**Longfield Solar Farm
Essex County Council (ECC)**

Unique reference: 20031541

ECC Responses to Written Questions (ExQ2)

Drawing Title
LAND PLAN IN ACCORDANCE WITH REGULATION 5(2)(i) OF THE INFRASTRUCTURE PLANNING (APPLICATIONS: PRESCRIBED FORMS AND PROCEDURE) REGULATIONS 2009
SHEET 1 OF 9

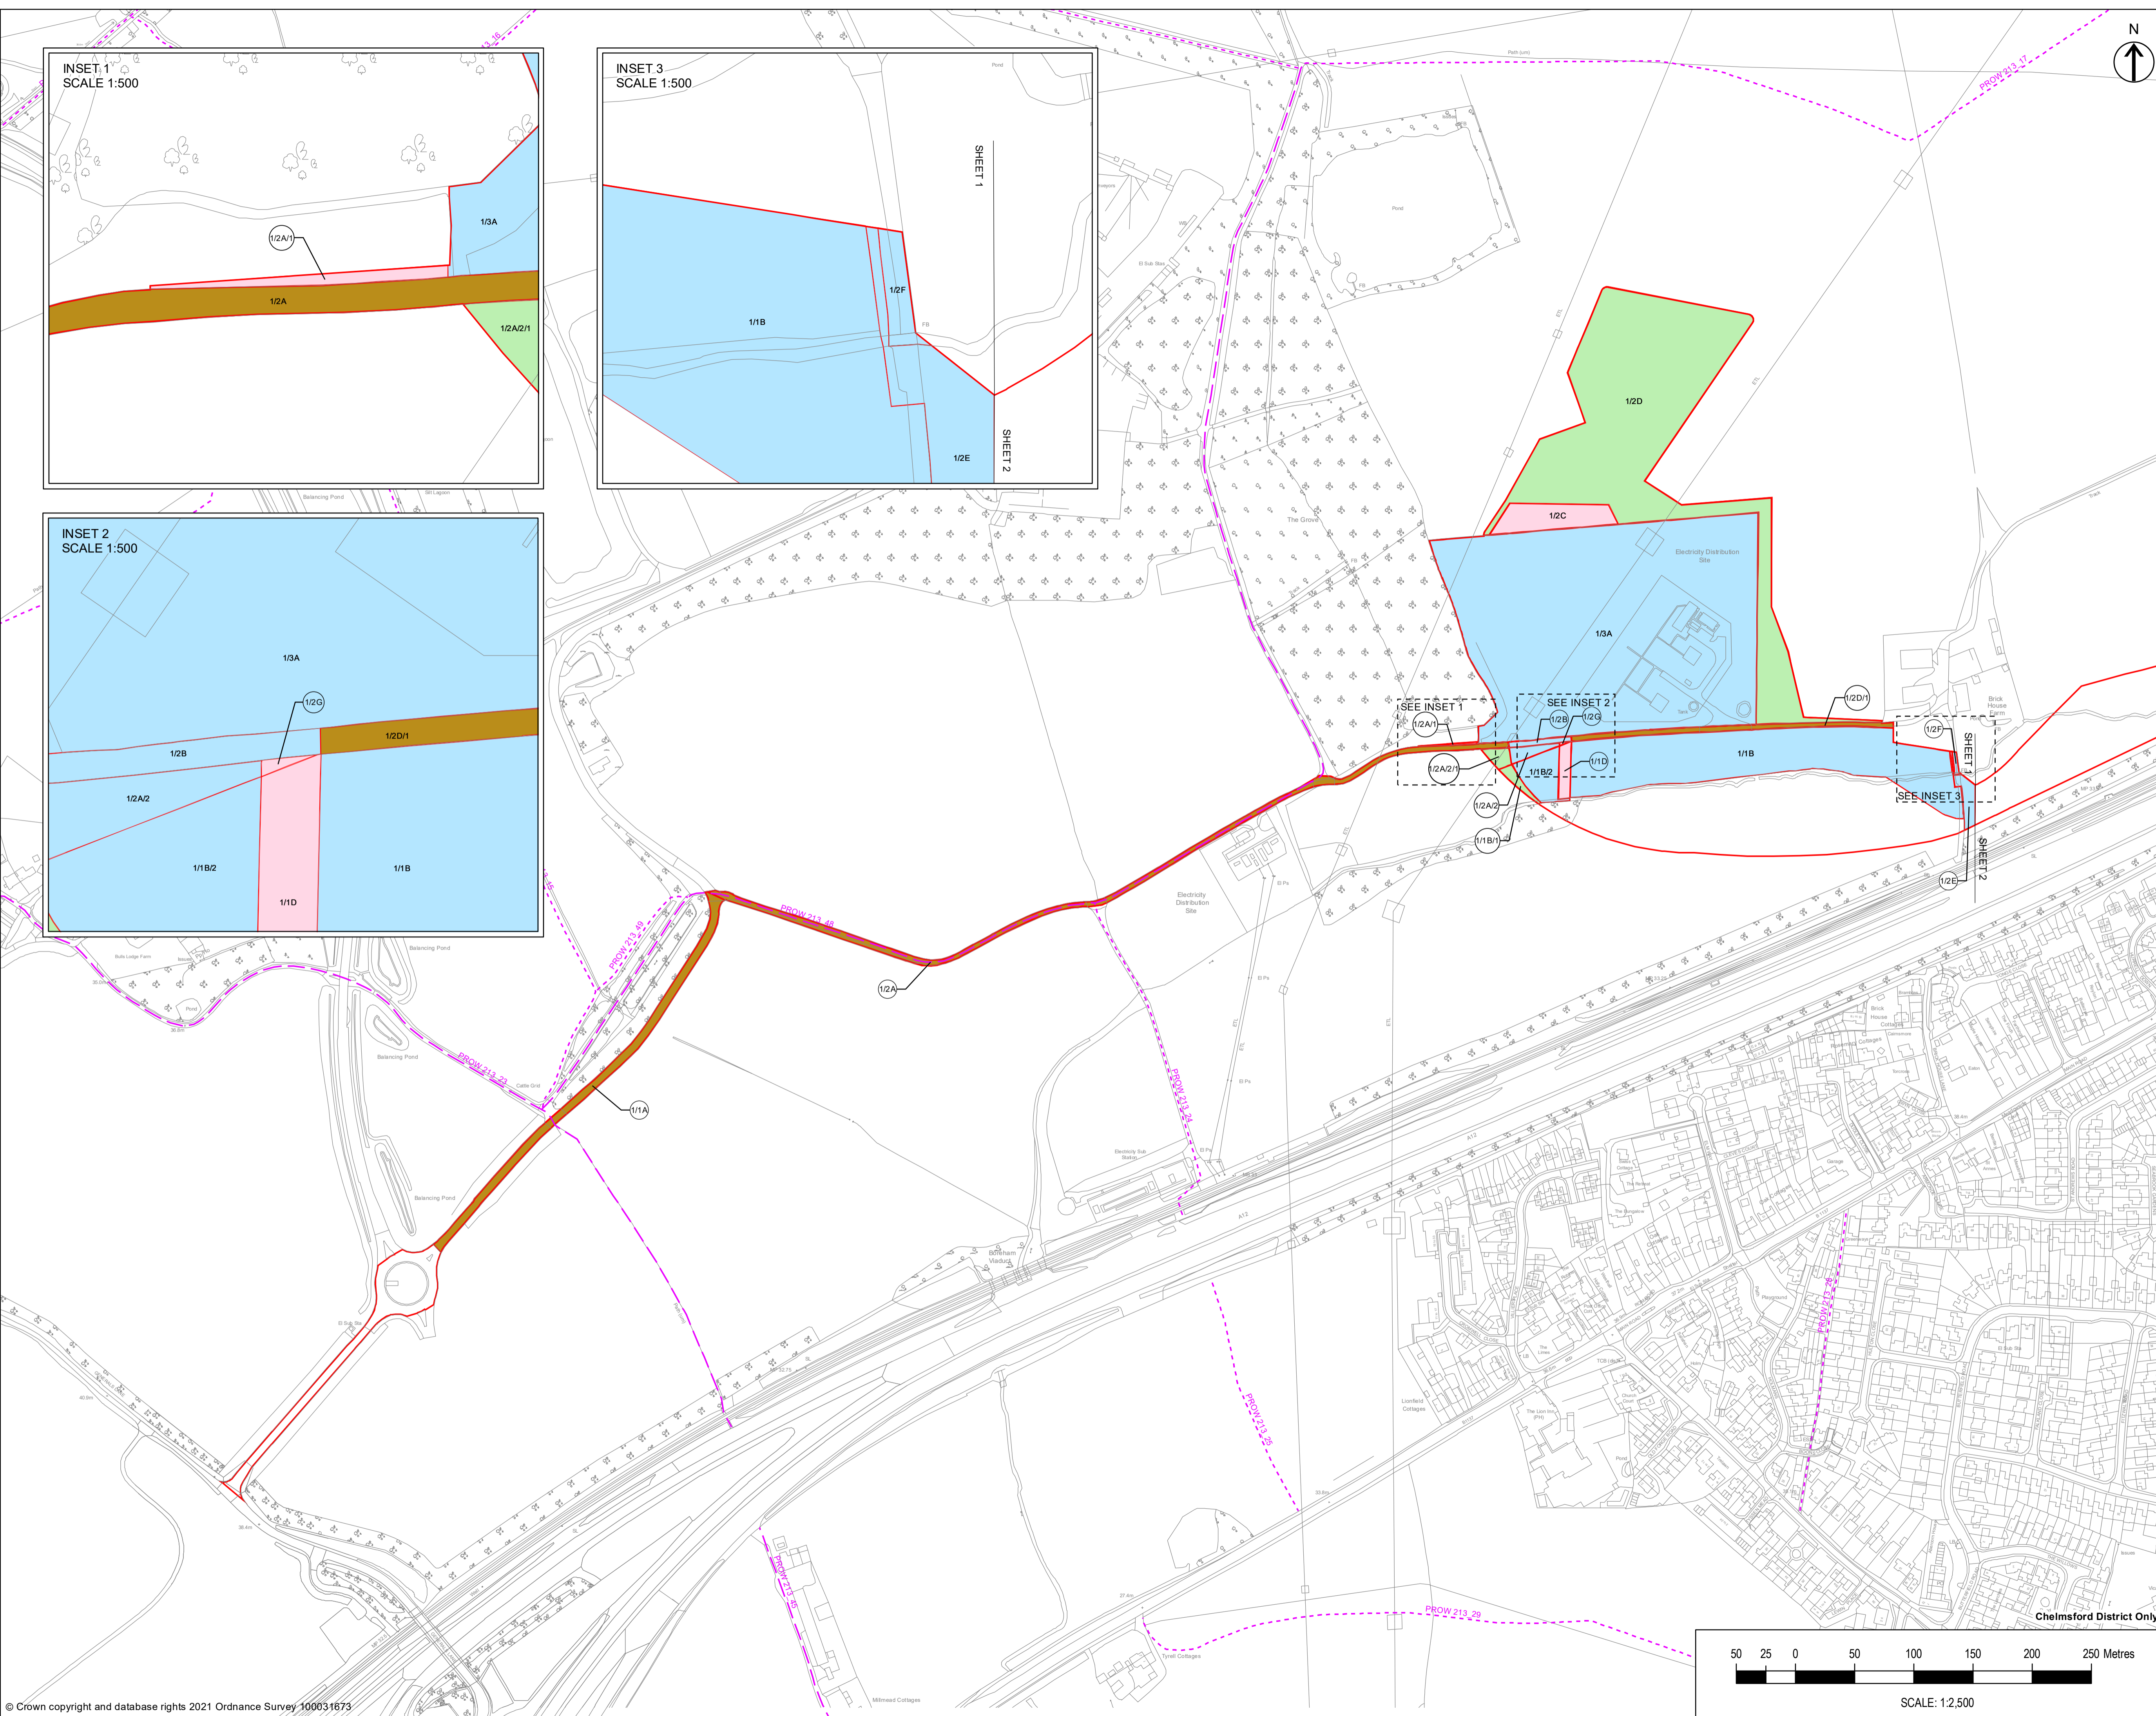
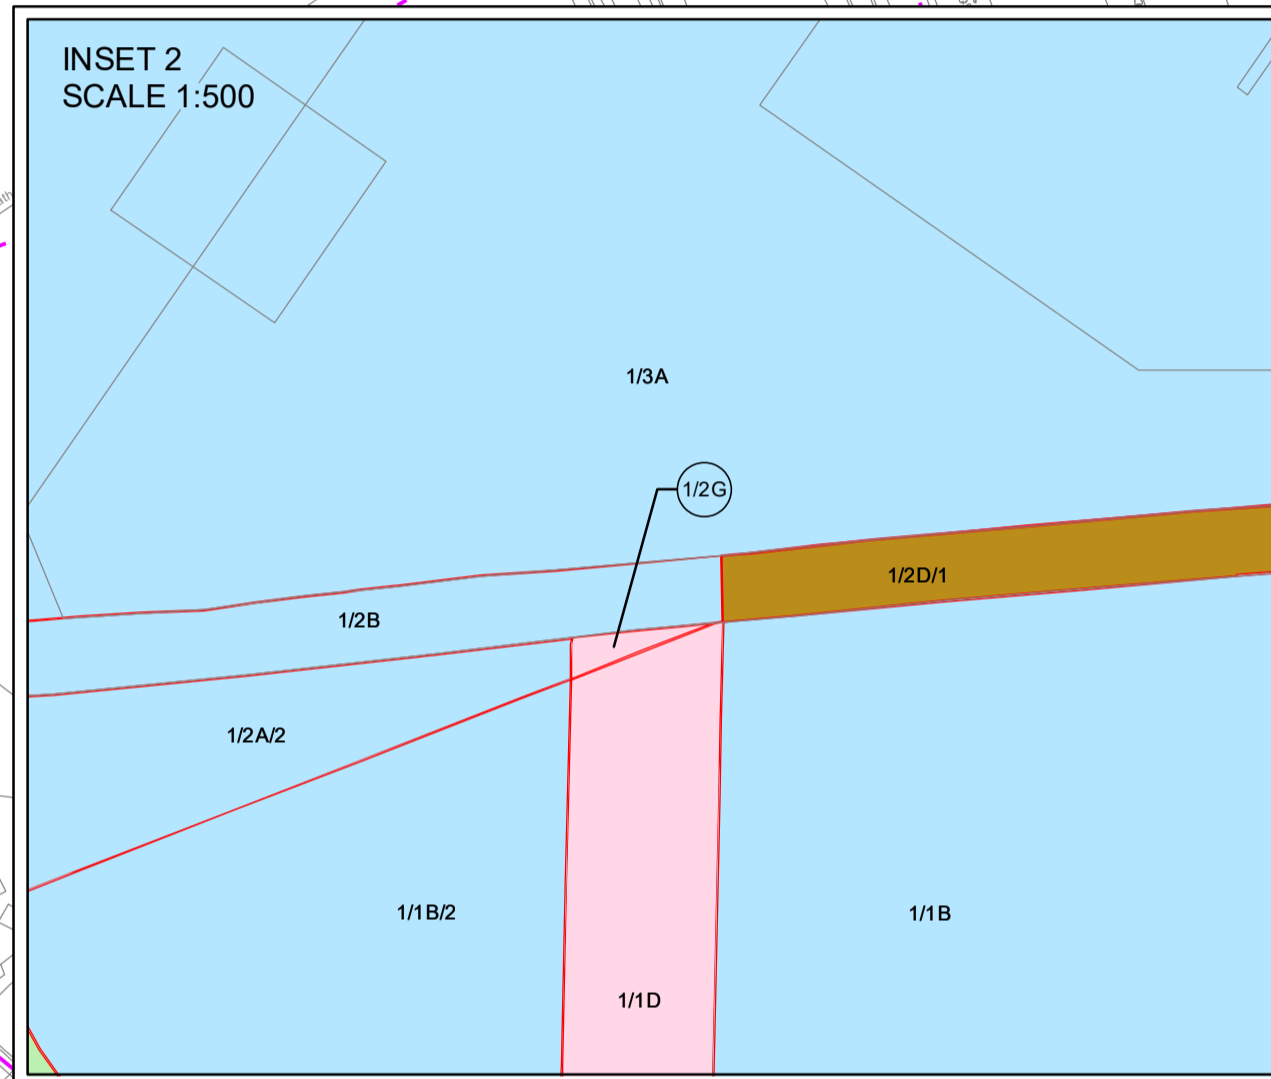
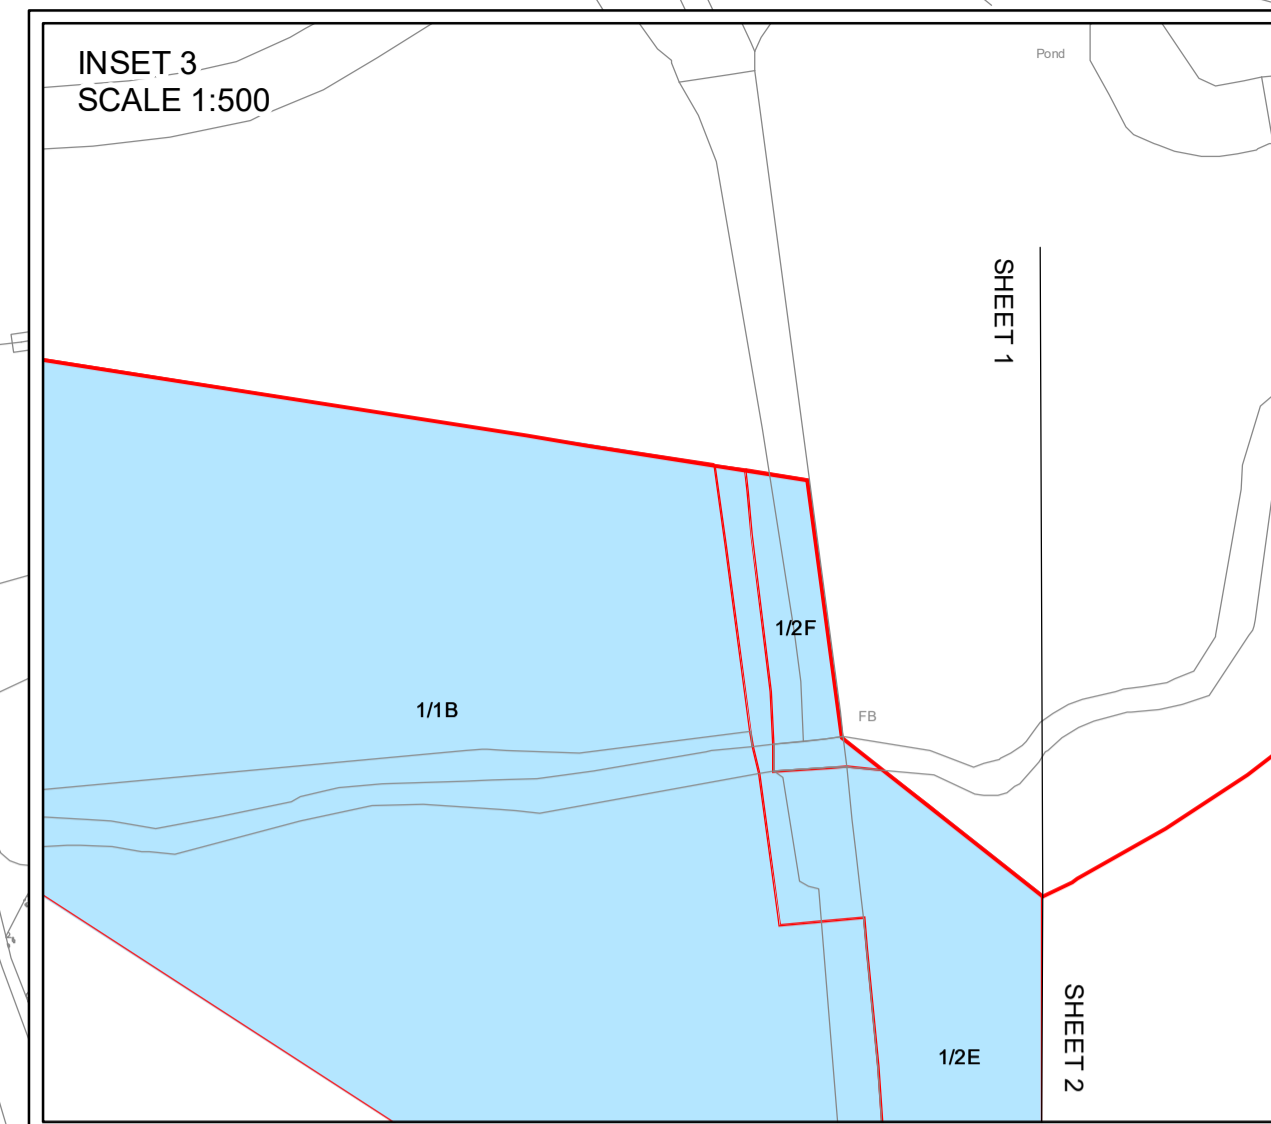
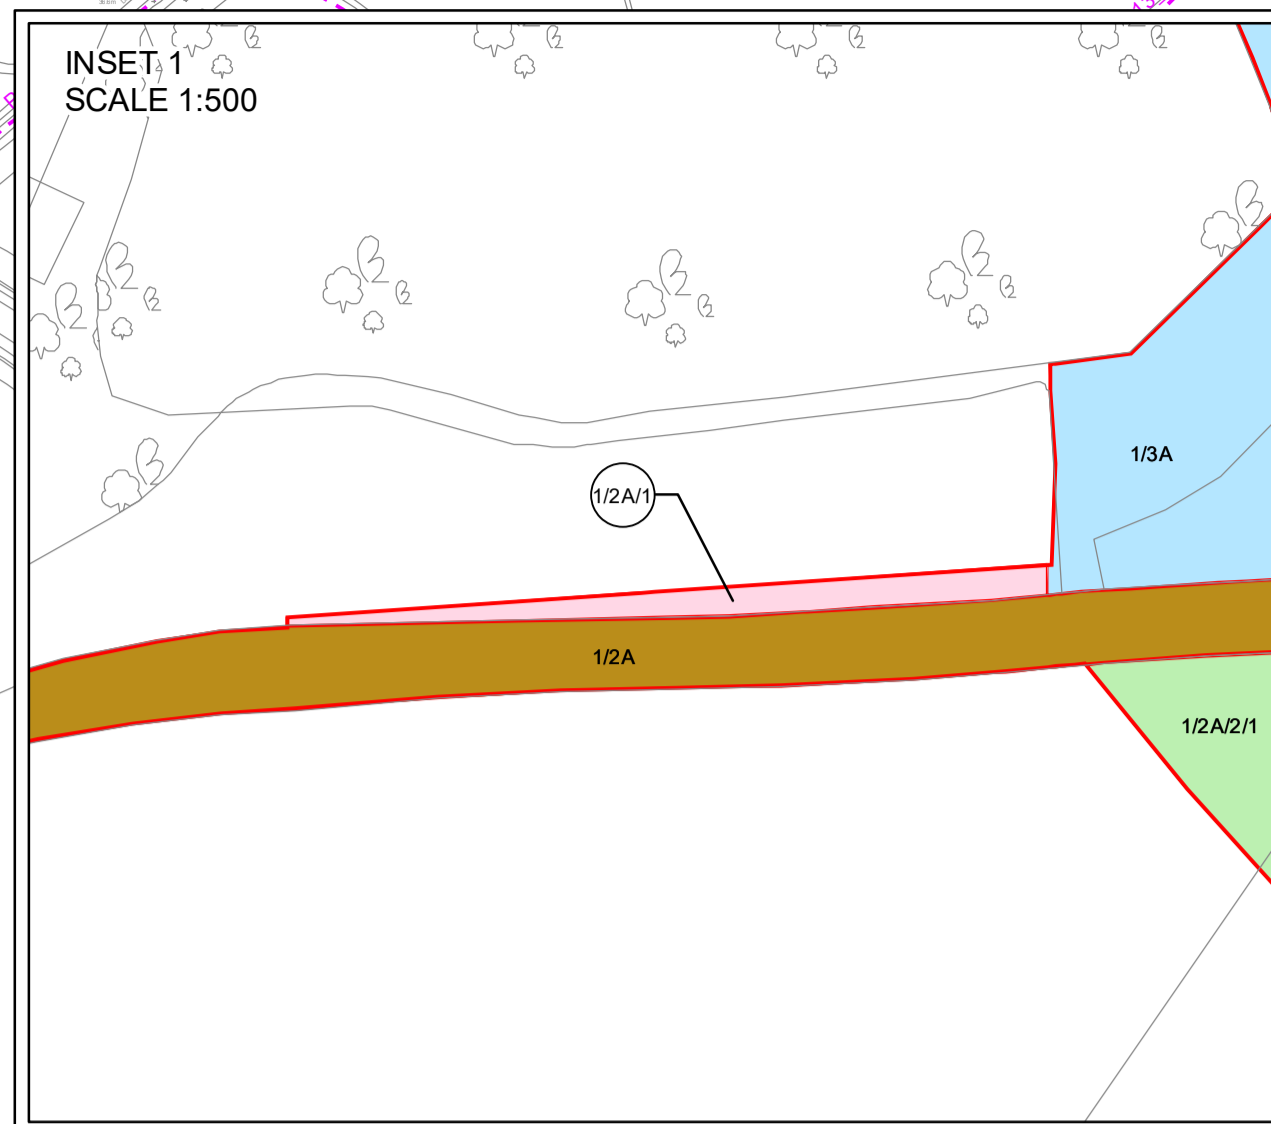
ExQ	Respondent	Question	Essex County Council response
2. Compulsory Acquisition and Temporary Possession			
2.3.2	Applicant/relevant Highway Authority	The Applicant explained at CAH1 that plot 1/1a had been removed from the BoR and Land Plans in anticipation of the land being adopted. Please provide an update on the expected timescale for adoption and whether this is likely to take place before the close of the Examination.	It is likely that later this month (Nov 2022) a certificate of completion will be issued in respect of the S278 agreement concerning the construction of roundabout shown on land plan 1/1a. This will formerly adopt the are subject to maintenance being the responsibility of the developer until issue of a maintenance certificate. Maintenance certificates will be issued a minimum of 24 months after the issue of the completion certificates. The two lengths of road NE and SW of the roundabout do not form part of this adoption. Planning applications that affect the alignment of these roads are anticipated in the near future as part of the development of this area. The extent of any adoption beyond the aforementioned roundabout is unknown. Discussions are ongoing between the Applicant, developer and Host Authorities regarding any required amendments to the land plans and limits of the DCO affected by adoption.
